# **RESPONSE TO SUBMISSIONS**

## **UNSW CLIFFBROOK (SSD 8126)**

17 OCTOBER 2017  
PREPARED FOR UNIVERSITY OF NEW SOUTH WALES

03 ELEVATION East Elevation 1:200

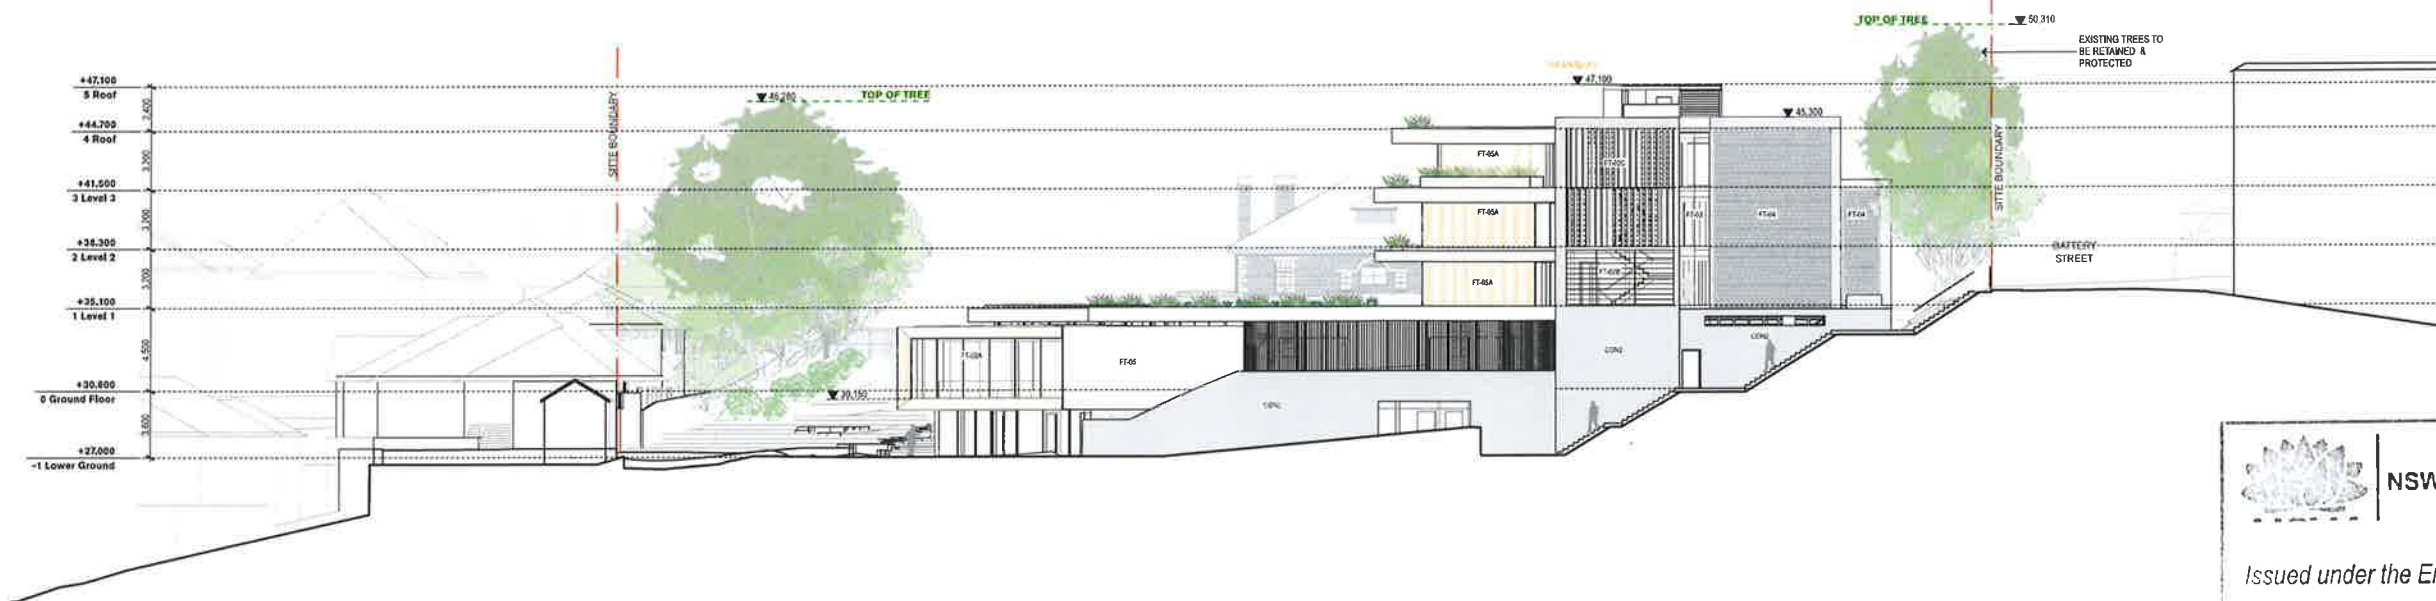
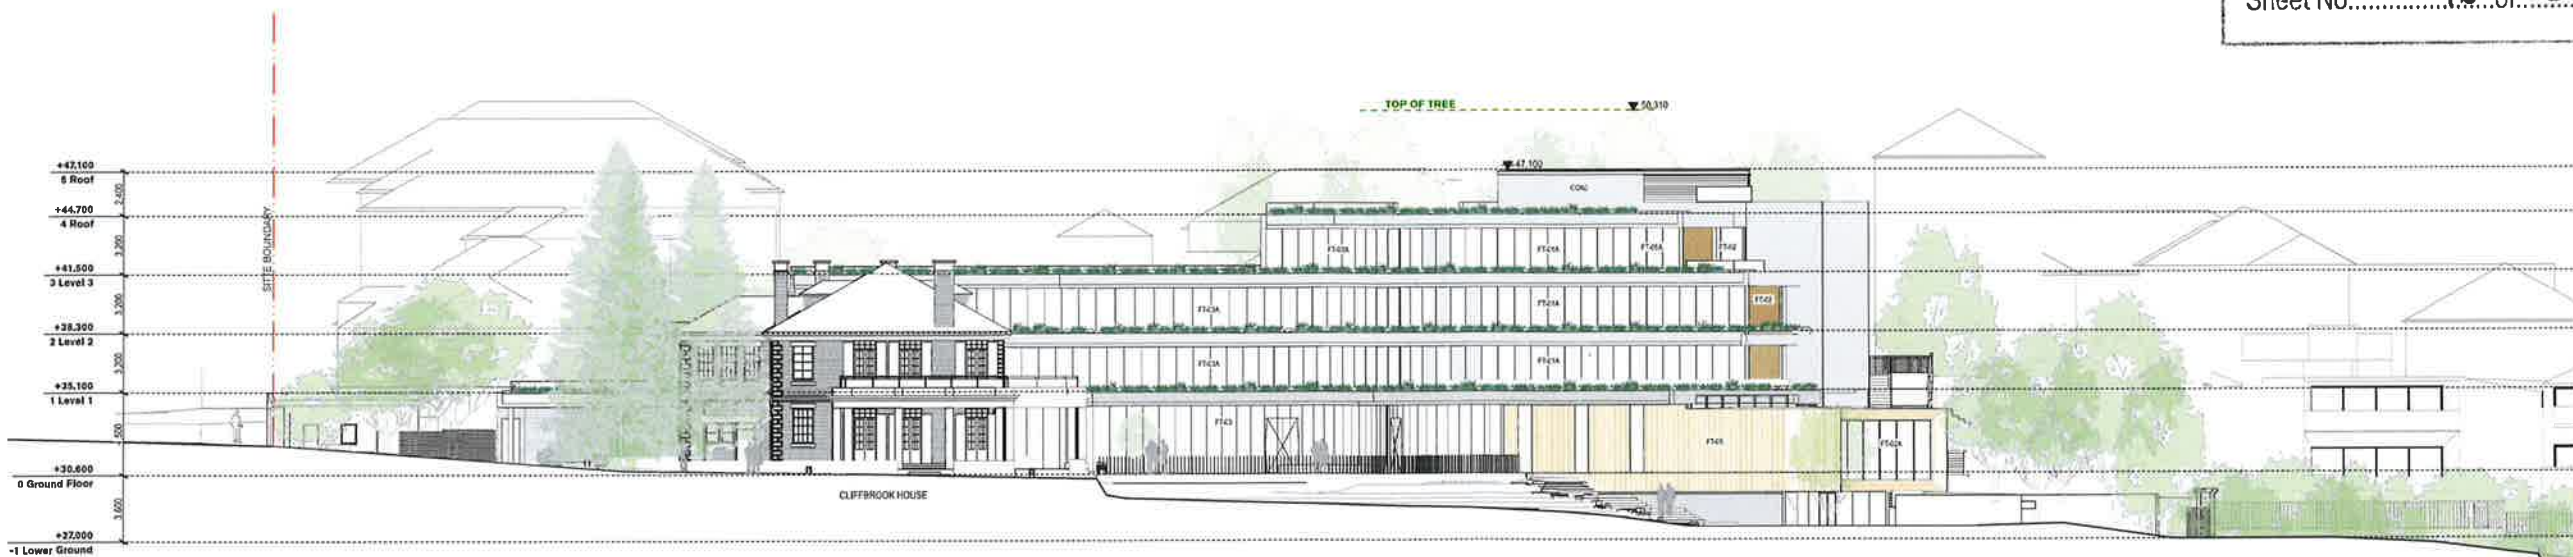
Issue	Submission Summary	Response
<b>Department of Planning and Environment</b>		
Built form and urban design	Opportunities to review and reduce the built form to the north-east corner and the resulting impact on the character of the streetscape should be investigated. Consideration should be given to the possibility of relocating plant uses to the lower ground floor level to aid in reducing bulk of the proposal	Refer to Section 5 of this report.
	The Visual Impact Assessment (VIA) recommends a range of measures which would aid in reducing the impact of the proposal to 44-46 Beach Street from a significant impact to an acceptable level. These measures, if applied, would change the building envelope of the proposal. The Department requires advice as to whether the recommended measures will be implemented and revised plans updated with these changes. If these recommended measures are not to be implemented, an addendum VIA is required advising whether the significant impacts to the views are still considered acceptable	Refer to Section 5 of this report.

In response to DPE's preliminary assessment and the submissions, the north eastern corner of the new building has been reviewed and amendments to reduce the impact on the streetscape on Battery Street and residents have been made. FJMT reviewed the bulk, height and streetscape appearance and propose the following design amendment as part of the RTS:

- The bulk of the north eastern corner is reduced through a 0.7m reduction in height of the roof plant and removal of the stairs,
- Relocated a bedroom from Level 2 on the north western end on Battery
- Reduced the parapet around the roof plant
- Reviewed the materials and finishes along Battery Street.

Revised elevations have been prepared and are submitted as part of the amended drawing set, however the figures below assist in articulating where the proposed reductions in bulk and form have occurred (as indicated in orange).
